**Our ref:** RA/2021/143639/02-L01  
**Your ref:** 2021/93567  
**Date:** 21 March 2022

### **ERECTION OF 194 DWELLINGS WITH ASSOCIATED WORKS – LAND OFF WESTGATE, CLECKHEATON, BD19 5DR**

#### **Environment Agency position**

Figure 1 - Environment Agency's Flood Map for Planning

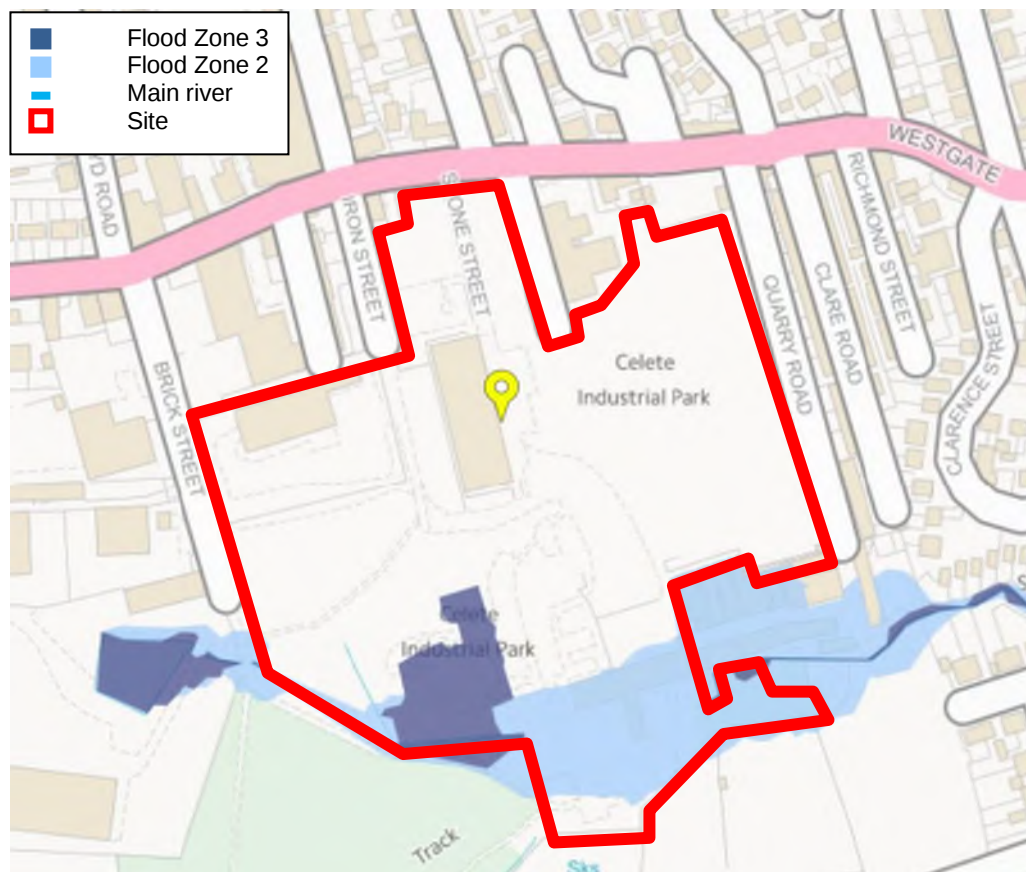
The EA Flood Maps stay as they are designated by us until any suitable revised and accepted modelled data becomes available at which time we may change them.

The applicant could apply to have the flood zones changed based on their data, however, this would have to meet specific criteria to be suitable for informing Flood Zones, which if accepted, would lead to a change in the flood zones. If the applicant would like to formally challenge the Flood Maps, they would need to submit an ERR (Evidence Review Request) to our Data and Evidence Team who can provide guidance on this.

Kirklees Flood Map – Fluvial Flood Zones

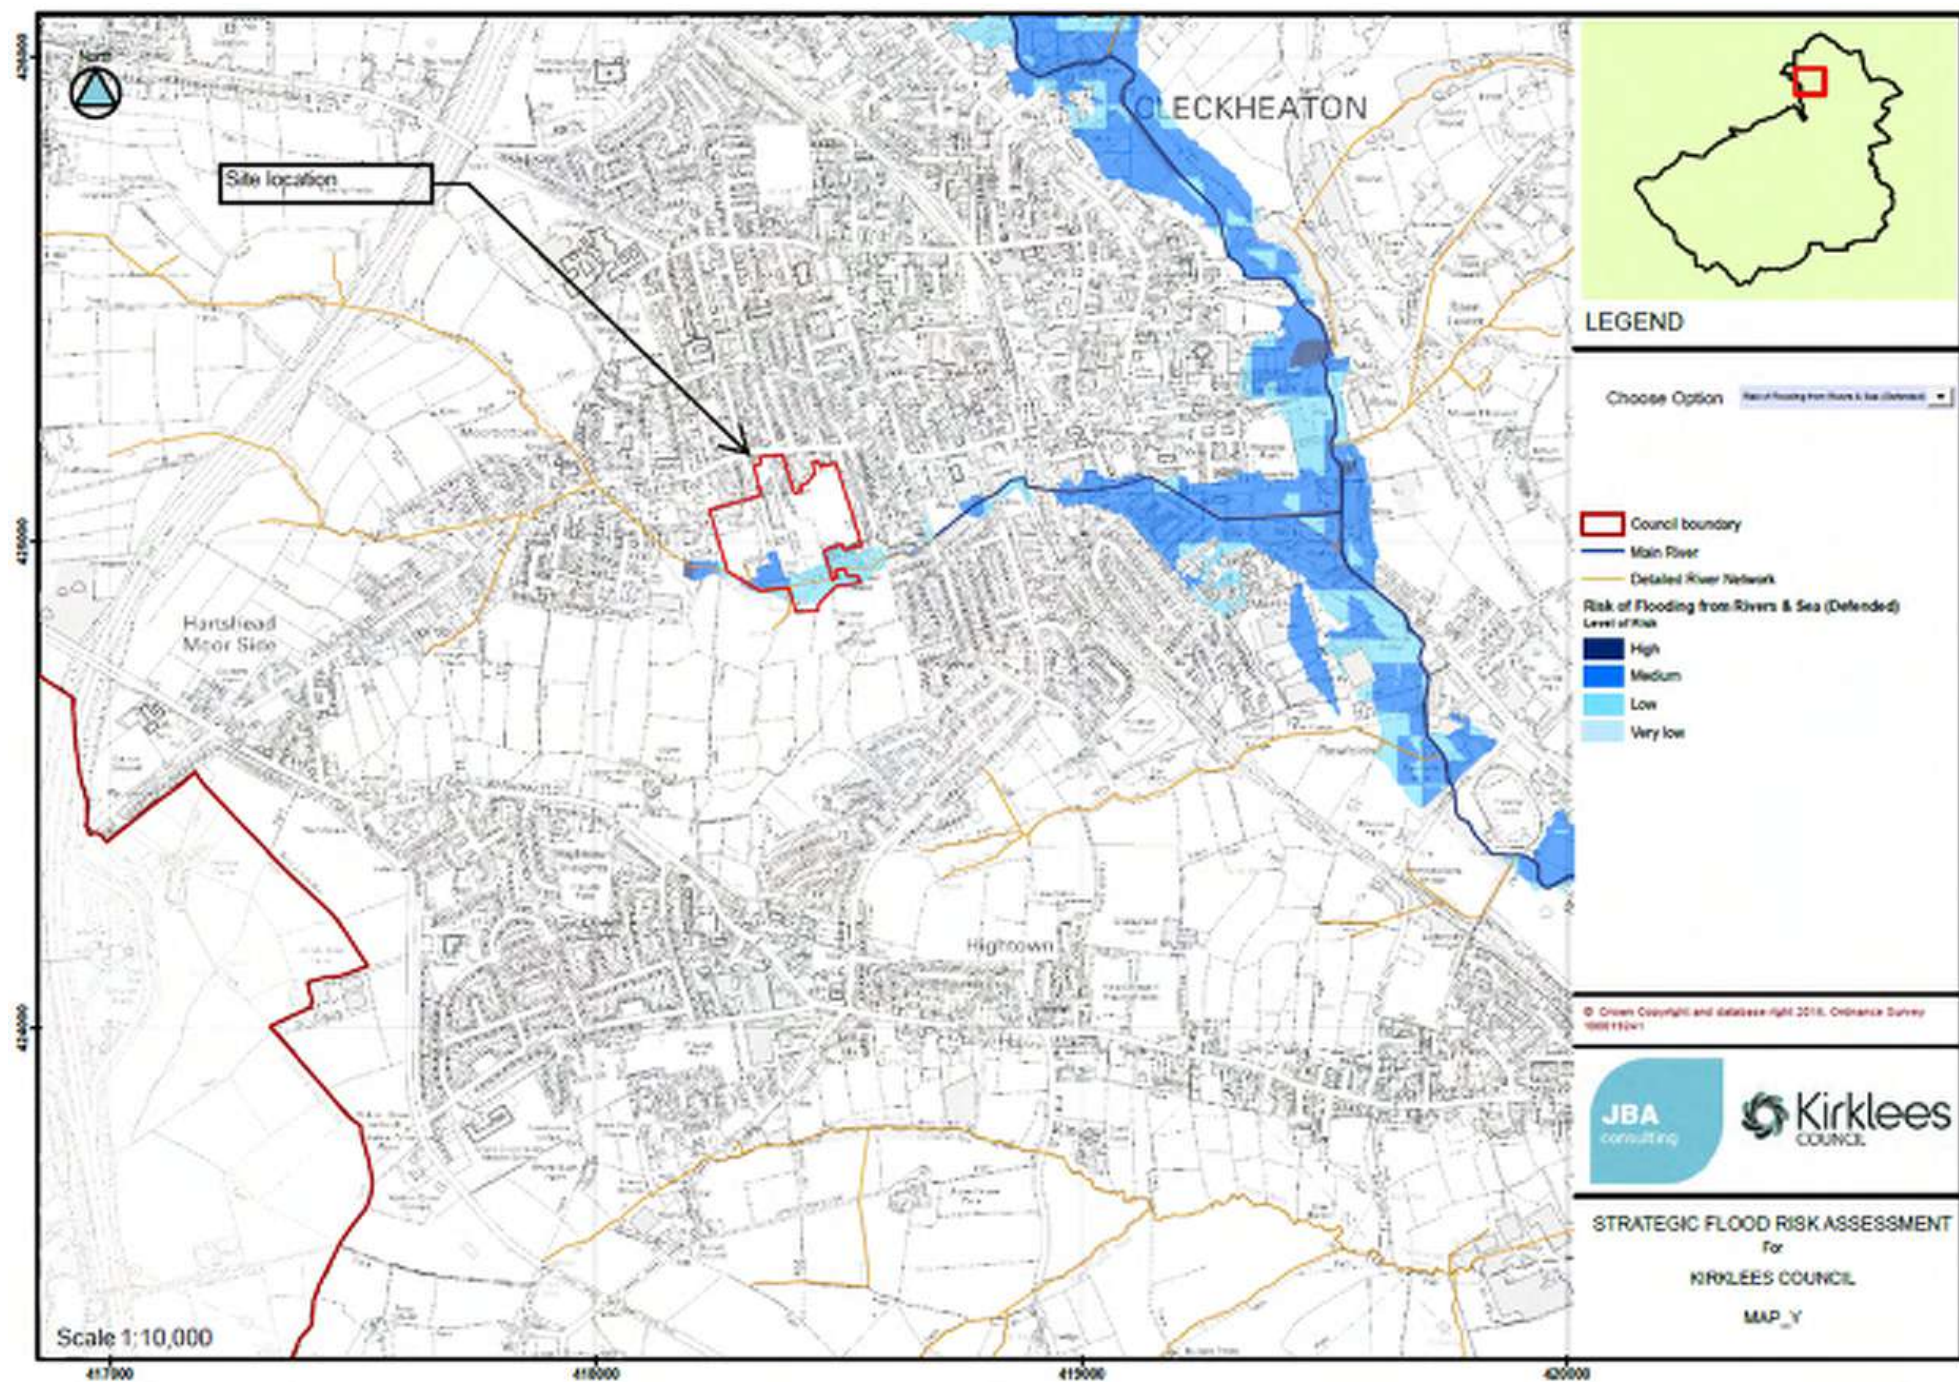
We recommend the site plan is overlaid onto Kirklees Council's Strategic Flood Risk Assessment (SFRA) maps showing flood zone 3ai to ensure there is no residential development, no loss of flood storage or land raising within this area. The Council need to be satisfied the development meets their SFRA policy on 3ai.

The SFRA maps showing 3ai are owned by the Council and any plans to update the Environment Agency's Flood Map do not automatically update the SFRA maps. We make the council aware of any changes we make to the Flood Map, however they are responsible for amendments to their own maps.
